Re: AC Hotel Portland - Internal Staff Comments - Ramps/Crosswalks & Lighting

I am getting back to you concerning the remaining PB approval conditions for the AC Hotel project. I have attached the Striping Plan prepared by Gorrill Palmer that address four

1 STREET TREE + LIGHTING PLAN

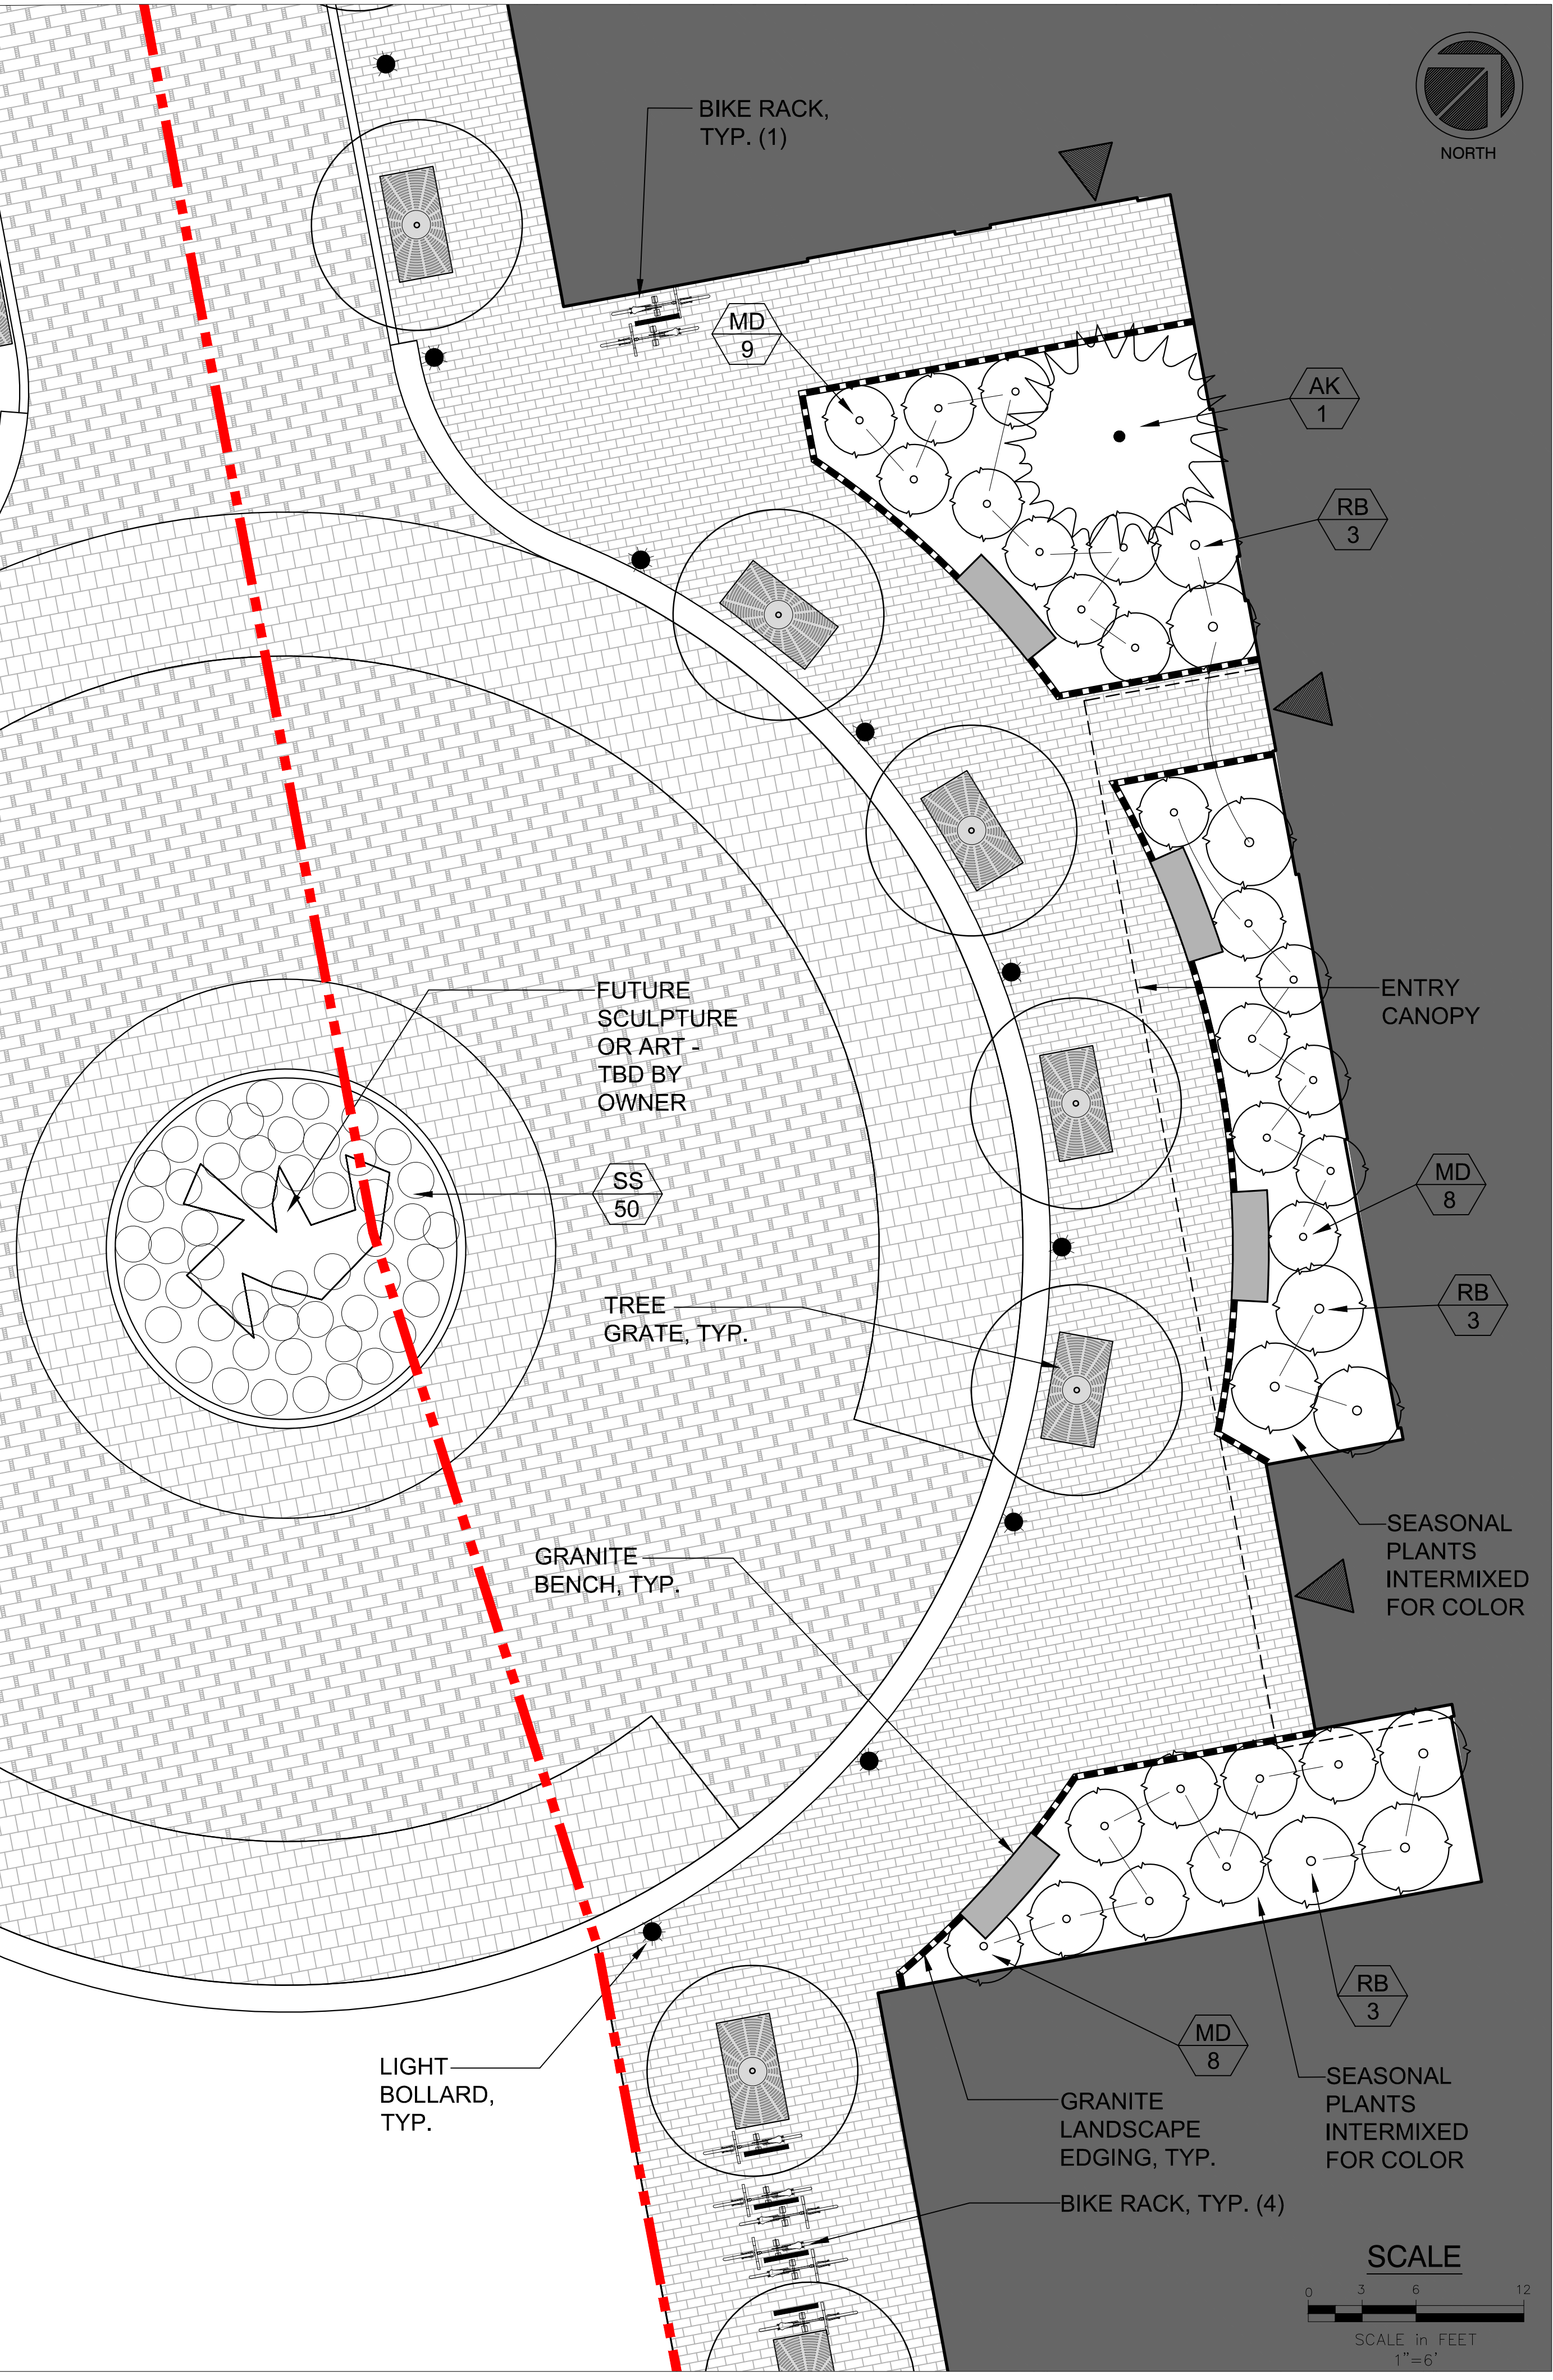
I would want to see the lighting plan to ensure that the crosswalks are adequately lit. We may want the light pole that is shown just west of Hancock on Fore Street to be moved

Filename: ... \000\Highway\002_Striping.dgn

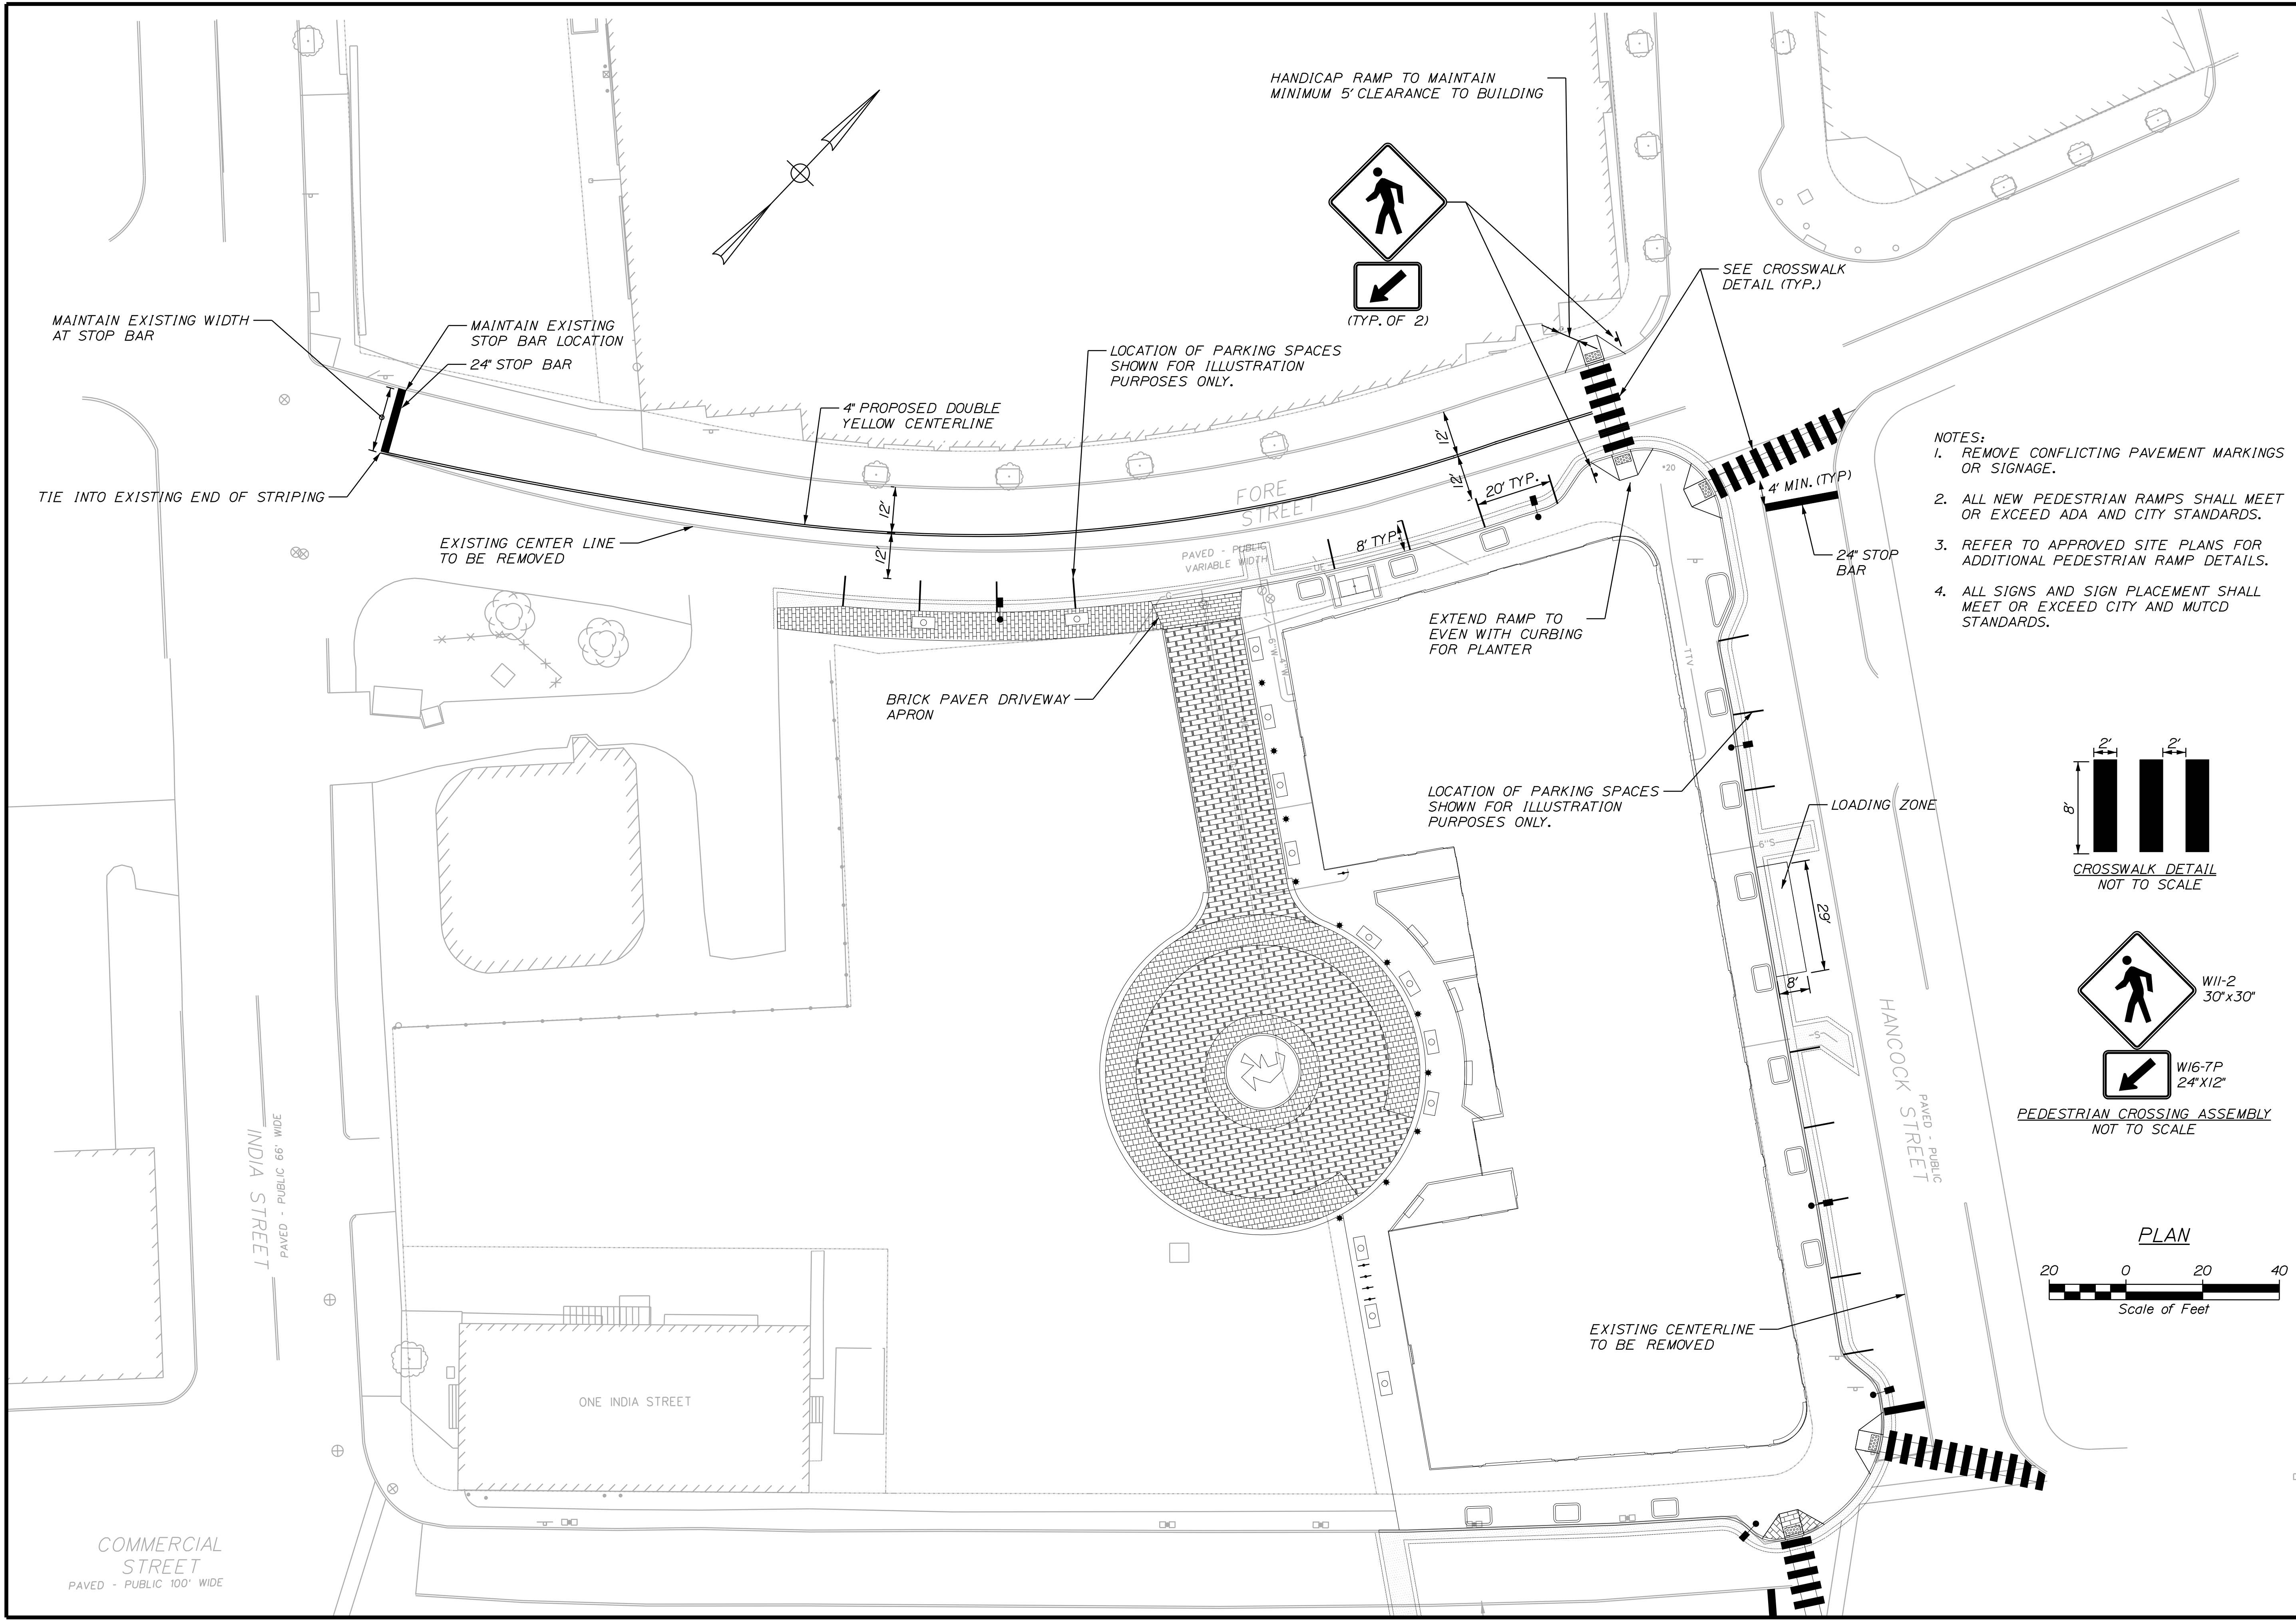
Hi Nell – Following discussions with DPW Operations staff, the center line should be located with equal 12-foot lanes. With this adjustment, the shift pavement markings through the Hancock Street intersection may not be necessary. Let me know if you have any questions.

I would suggest we discuss today at 1:30pm. My suggestion would not to have the transition markings and adjust the center line east of Hancock.

On Fore Street we do want that line, and more than 12 feet adjacent to parking (13 would be fine).

Unless there is a centerline now on Hancock, we don't need it, and we don't tend to paint loading zones. I'm fine with removing them.

The STOP bar on Fore Street should be deleted.

Parking spaces are NOT to be marked and can remain for illustration purposes only.

Warning signs at the crosswalk should be noted – unless Bruce and Jeremiah do not think necessary

I agree with Bruce that the ramp from the project corner to the SE corner of Fore/Hancock should be adjusted to reflect a two-ramp scenario. A slight shift of the ramp.

Center line marking – Bruce/Jeremiah: Are we okay with two 12-foot lanes? Or do we want a wider lane abutting the parking? It also does not transition across the Hancock intersection.

Jeremiah – should the loading zone be painted? I would suggest signs only.

At the Thames intersection – why not have them design the ramps with redevelopment in mind. Just a slight rotation of ramp. Not a big deal.

I am generally in favor of the ramp configuration as shown at Thames/Hancock Streets. It anticipates pretty well a future new 2 ramp configuration across Hancock Street. It is skewed for the short term but I'd imagine something happening here fairly near-mid

I do like the new alignment for ramps and crosswalk across Fore Street serving the garage but the configuration of the ramp in front of the parking garage may need to be changed to allow for up to 5' of depth for the landing area IF the landing butts

up against a building or other vertical element. It looks like it is just aligned with the recessed area of the building but I'd want assurance that there is sufficient clearance for wheelchair users or others to continue to travel along Fore Street without

traversing the flares of the curb ramp. It might need to be moved a couple of feet to the east (toward Hancock) to achieve adequate clearance. At a minimum, I'd want confirmation that the cross-slope for the sidewalk leading up to the shown landing area does

I don't think the ramp serving the crossing of Hancock Street anticipates as well a potential future 2 ramp configuration on the SE corner of the intersection. It doesn't look like anything precludes the ramp to be moved a couple of feet to the south along
